Pear tree Hill Solar Farm

Response to Deadline 4 Submissions

Application Document Ref: EN010157/APP/8.23
November 2025

Figure 14.2: Transport Routing and the Existing Highway Network

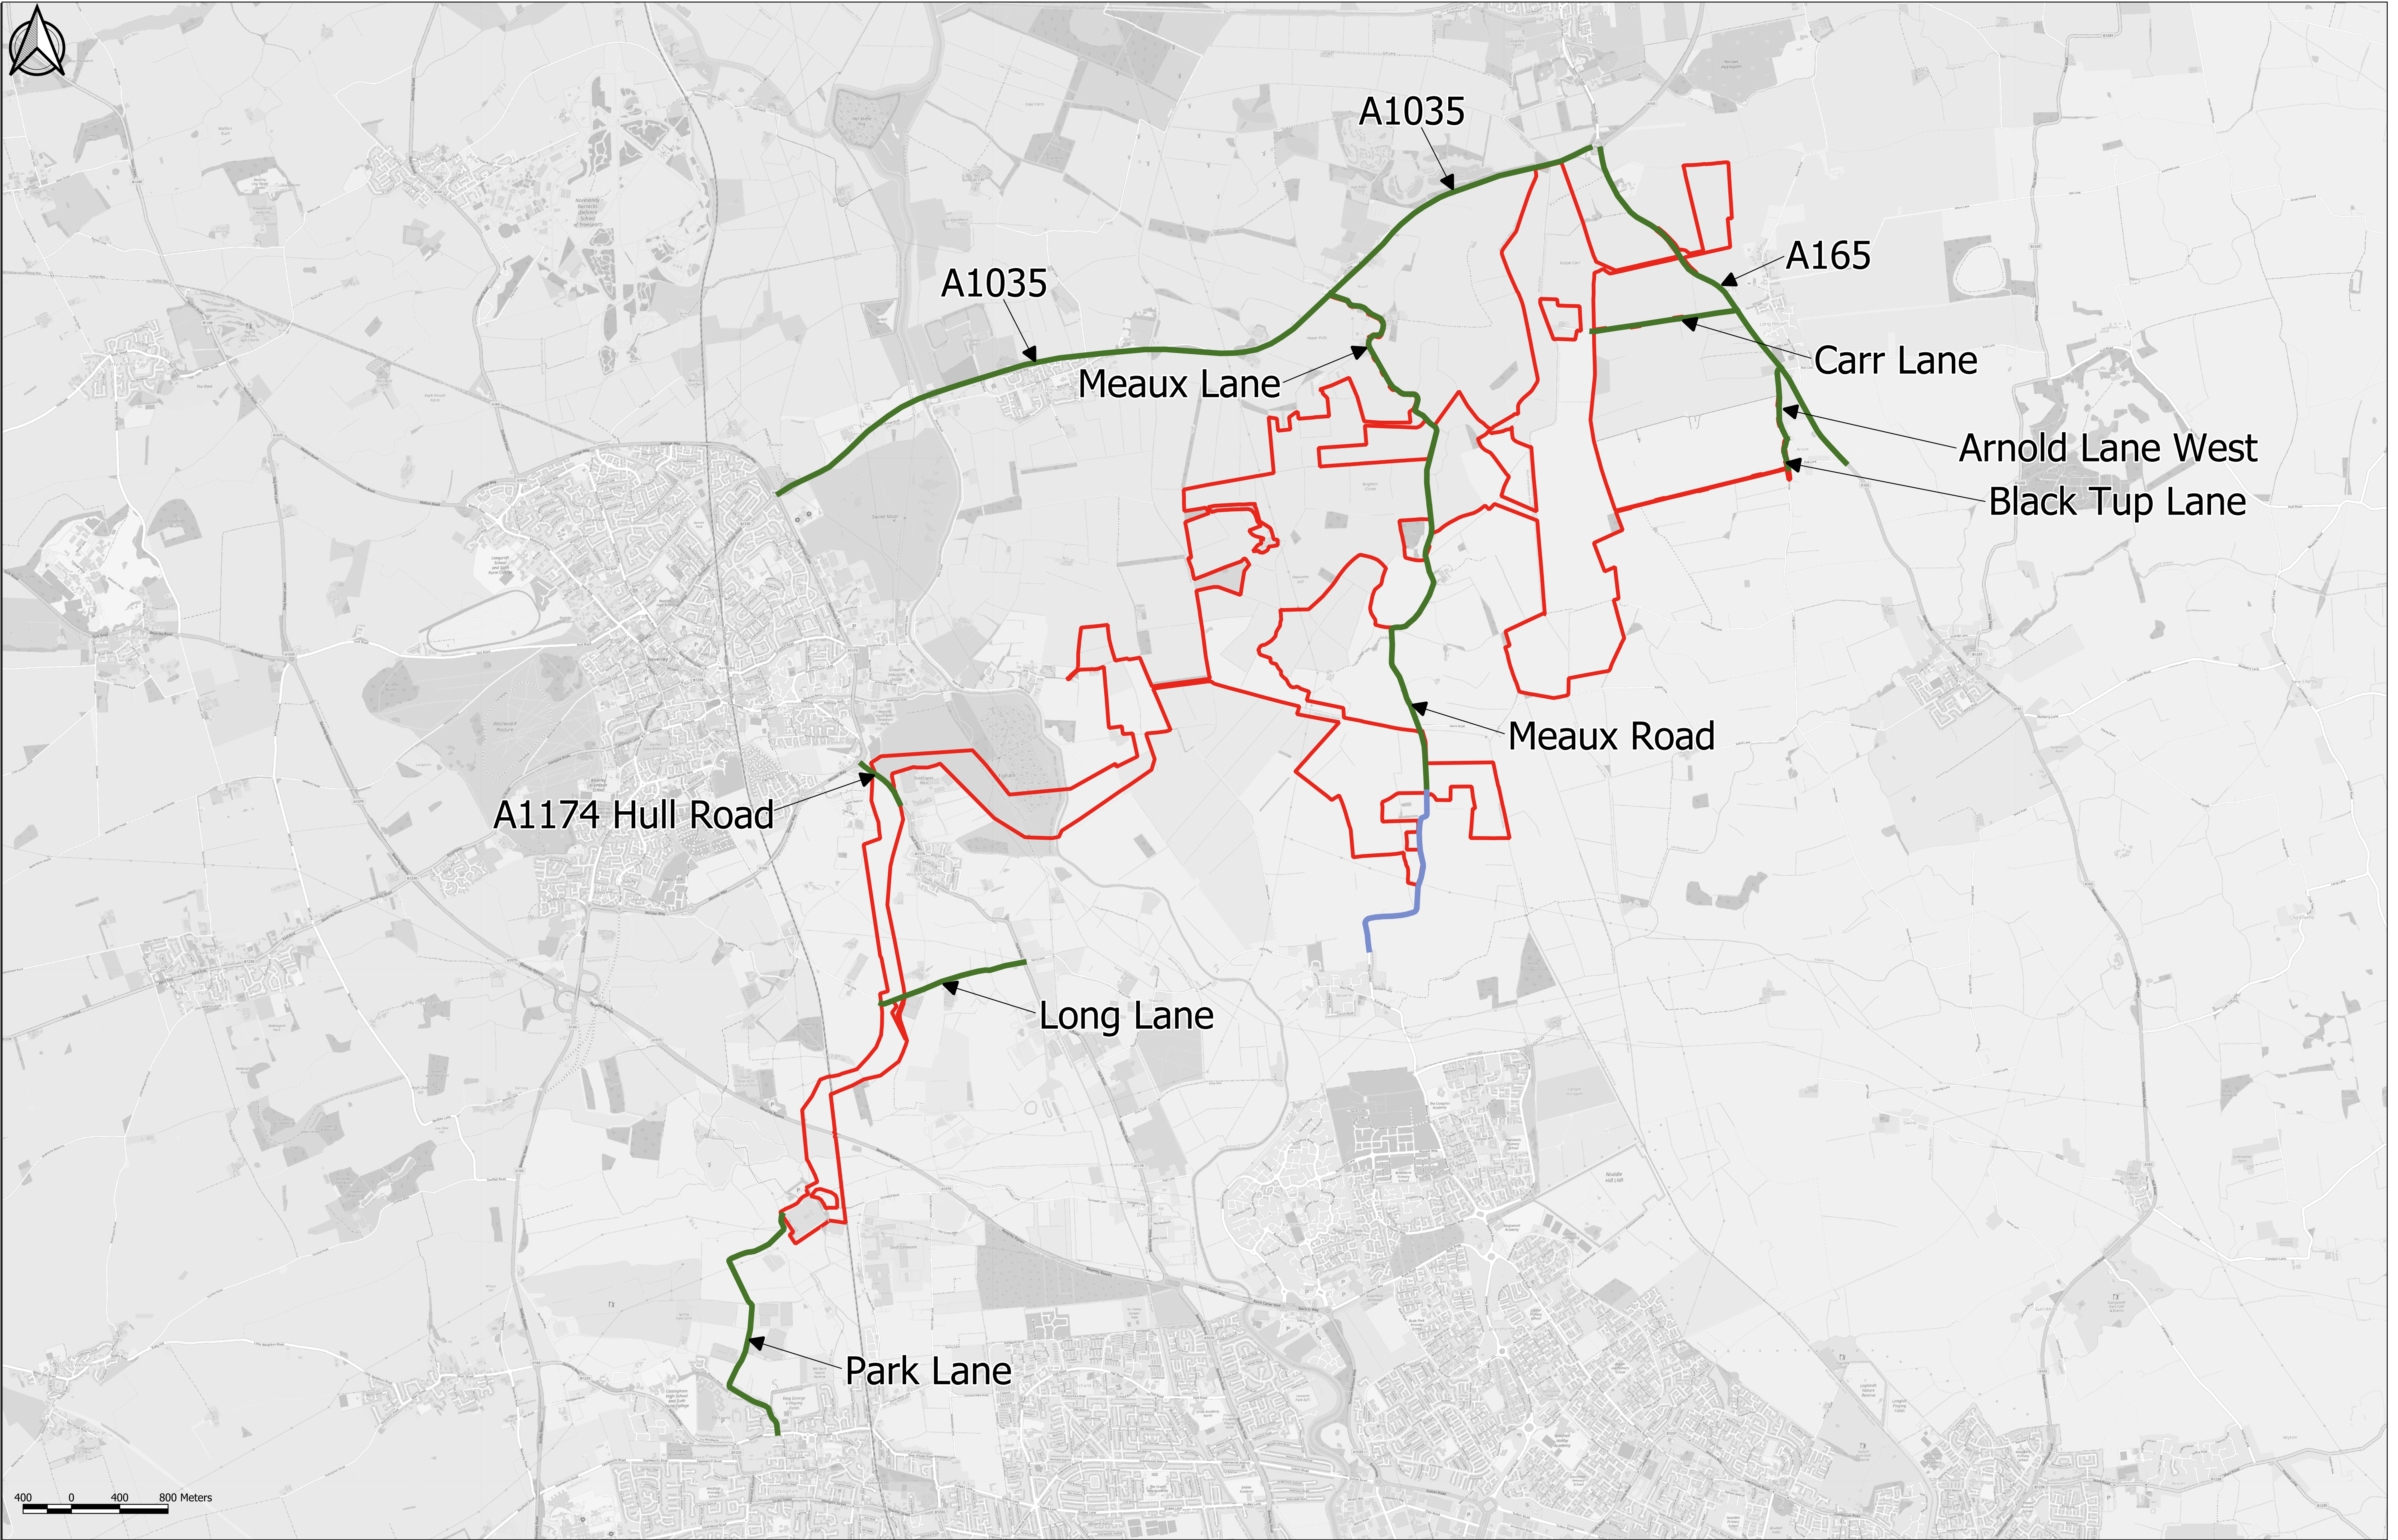
Written summary of oral submission made at Issue Specific Hearing 2 [REP4-082]	
Highways	
There has been no change in ERYC's position on the use of Park Lane.	The Outline CTMP [REP4-031] that was submitted at Deadline 4 was updated to include a commitment that the Applicant will explore the use of an alternative access which is planned to be created off the A1079 in association with the Wanlass Beck substation. Following further discussions with ERYC via email on 29 and 30 October 2025, text has been added to the relevant

Mitigation suggested by ERYC would be to use an alternative access, such as those pending planning permission from the A1079, should Park Lane be accepted for use for the ExA, additional passing places, temporary traffic Regulation orders and parking restrictions should be considered	The section of Park Lane between Northgate and the junction with Badgers Wood (to the north of which Park Lane becomes an unmarked track) has a carriageway width which ranges from approximately 5.8m to 7.2m, the minimum required width for two HGVs to pass is 5.5m (as set out in the Department for Transport's Manual for Streets). Parking along this section of Park Lane is sporadic and the width of the road enables plenty of opportunities for vehicles to give way and pass.

East Riding of Yorkshire Council Response Summary	Applicant Response
	<p>To the north of Badgers Wood, the track narrows to generally 4m in width and there are approximately 9 existing passing places along the remaining section of Park Lane up to the access to Creyke Beck substation, at which point the track widens to approximately 6.5m.</p> <p>On this basis, it is considered that no further passing places or measures above and beyond that which is already proposed are required.</p> <p>Additionally, as is outlined above, a number of management measures are proposed which are considered to suitably manage the low number of construction vehicles in a safe and efficient manner.</p> <p>The Outline CTMP [EN010157/APP/7.7 Revision 6] includes a commitment that the Applicant will explore the use of the alternative access which is planned to be created off the A1079 in association with the Wanlass Beck substation and that in the event that the Applicant is in a position to utilise the alternative access off the A1079, it would no longer seek use of Park Lane. The Applicant is continuing to liaise with ERYC on this matter.</p>
